RE: AI Job #19037

Project Address: 7233 80th Ave SE

Subject: Permit No. 2008-182

PLAN REVIEW COMMENTS

SHEET
A2.1

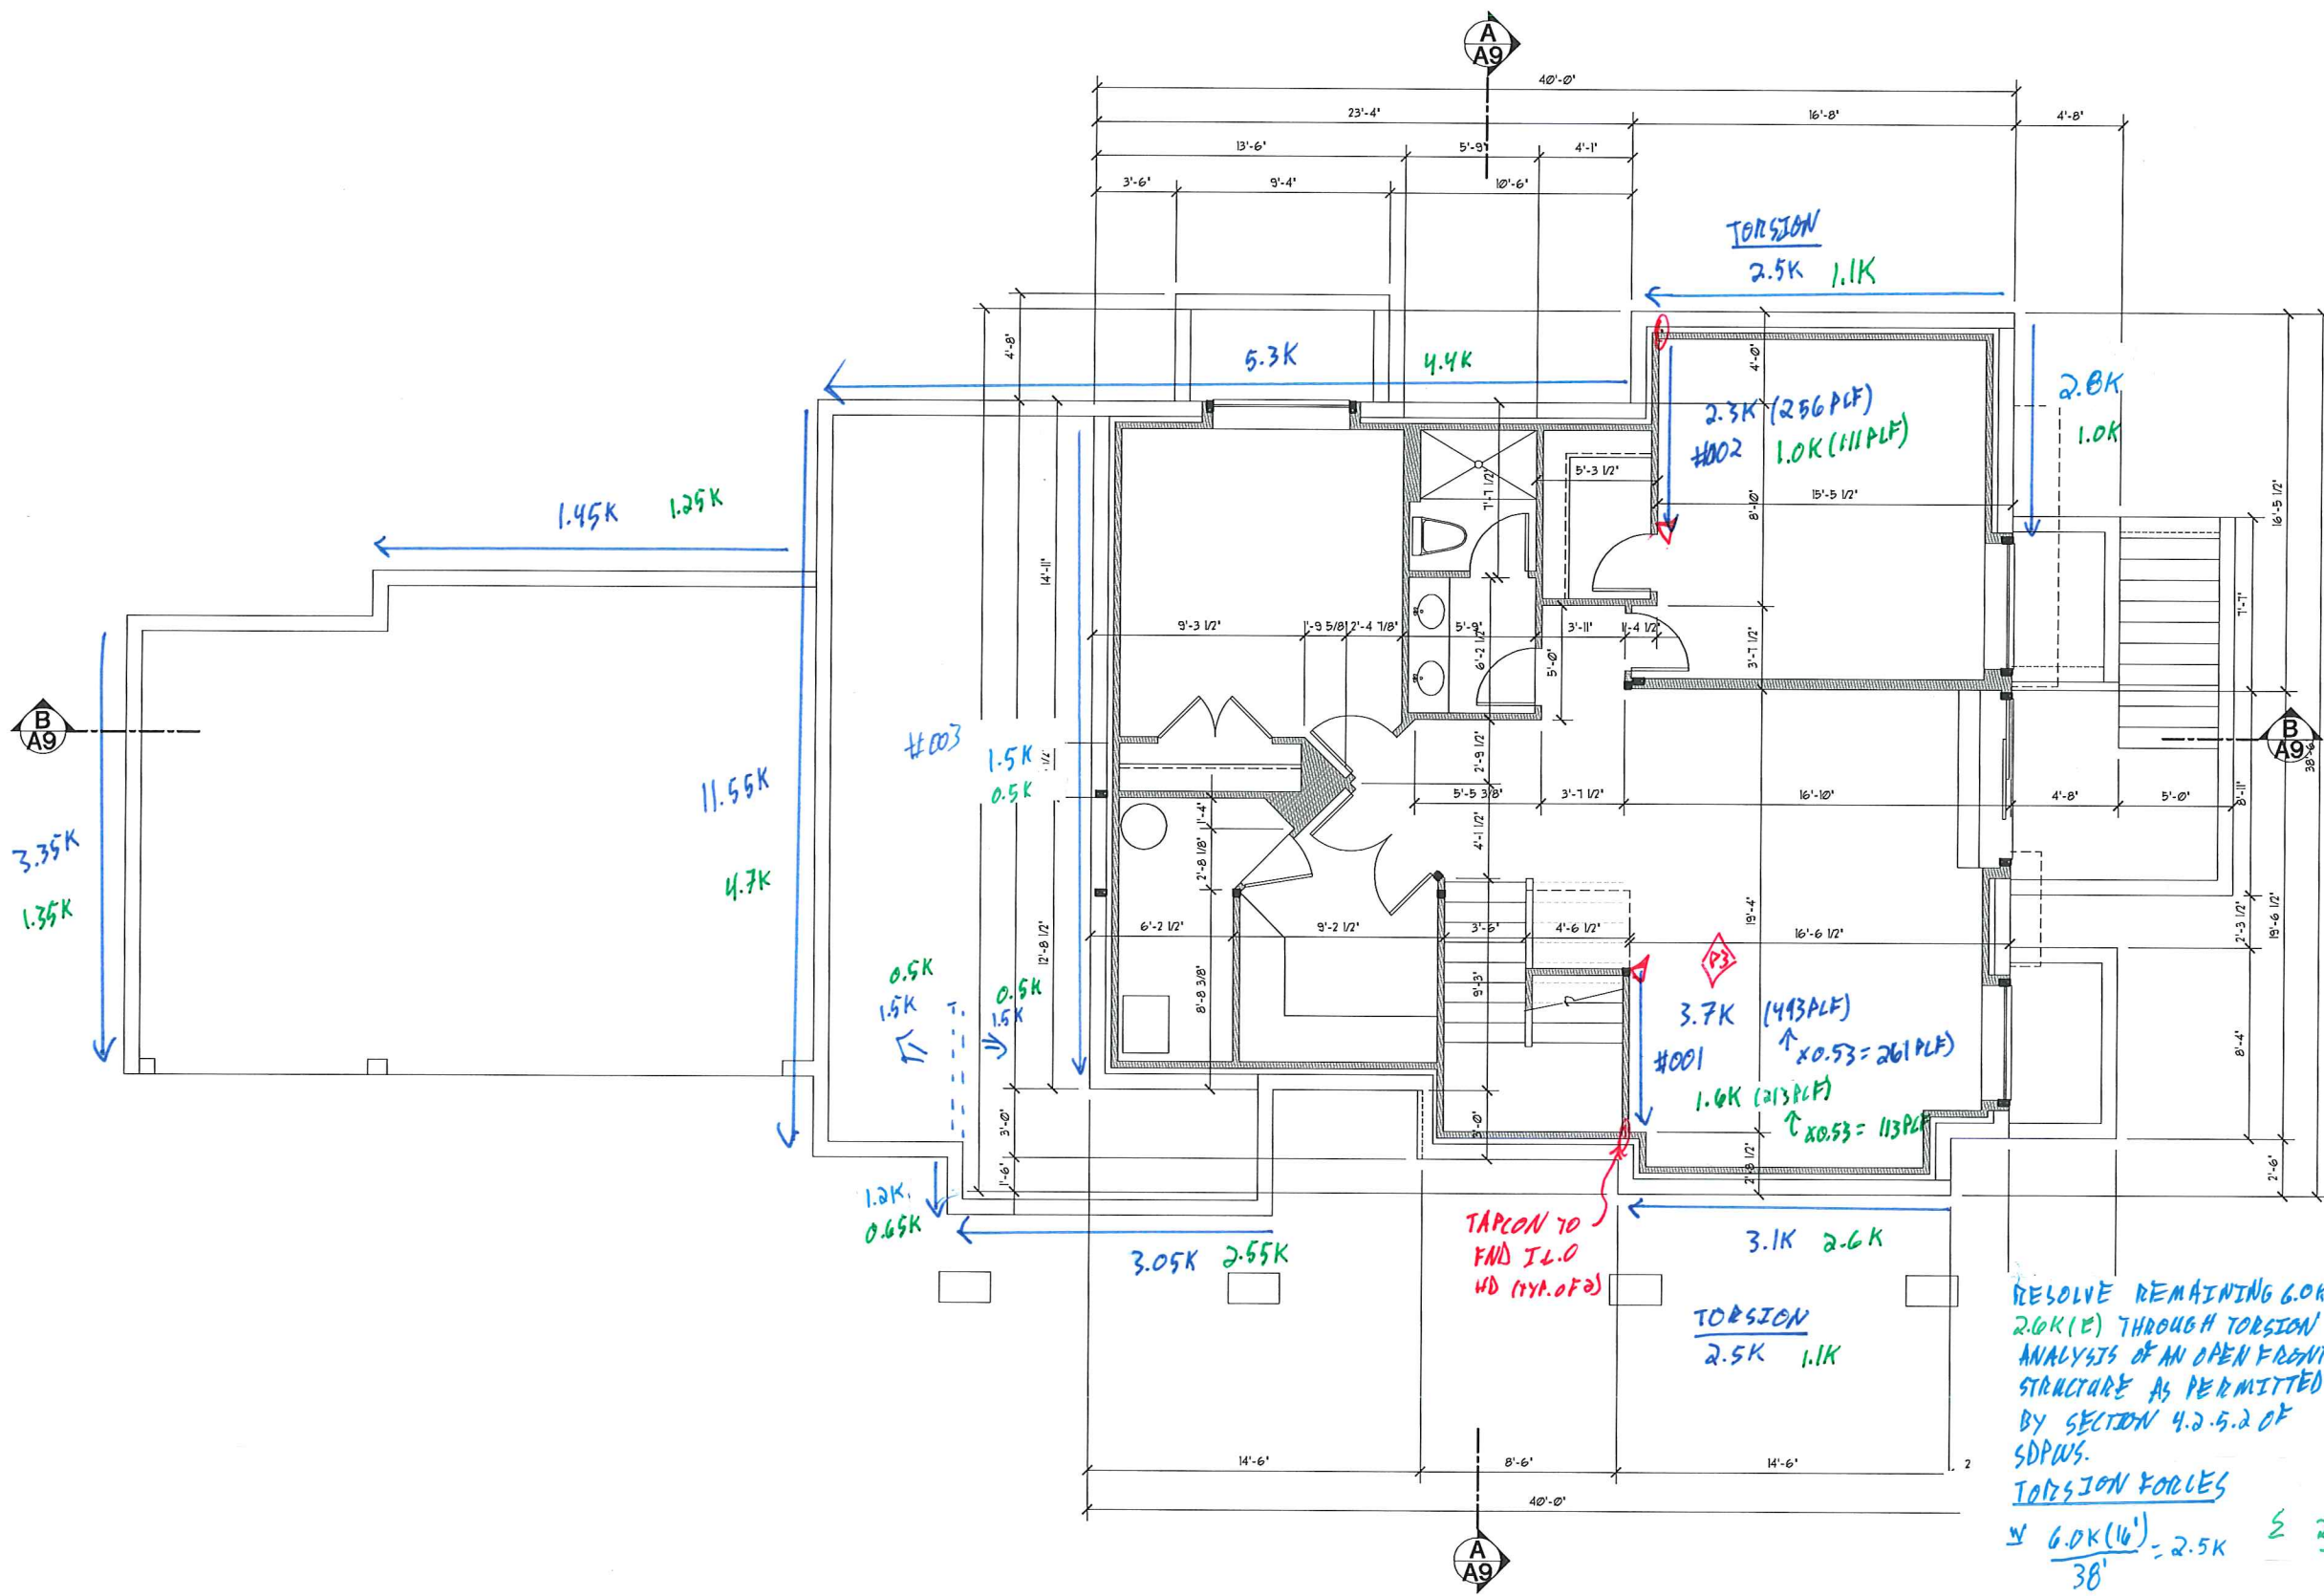
3. a. Corrected the detail reference.
b. Added detail 10/D1 and added references to the detail on sheets A.0 and A2.1.
4. The details on sheet SD.01 refer to the Architectural plans for waterproofing and drainage.
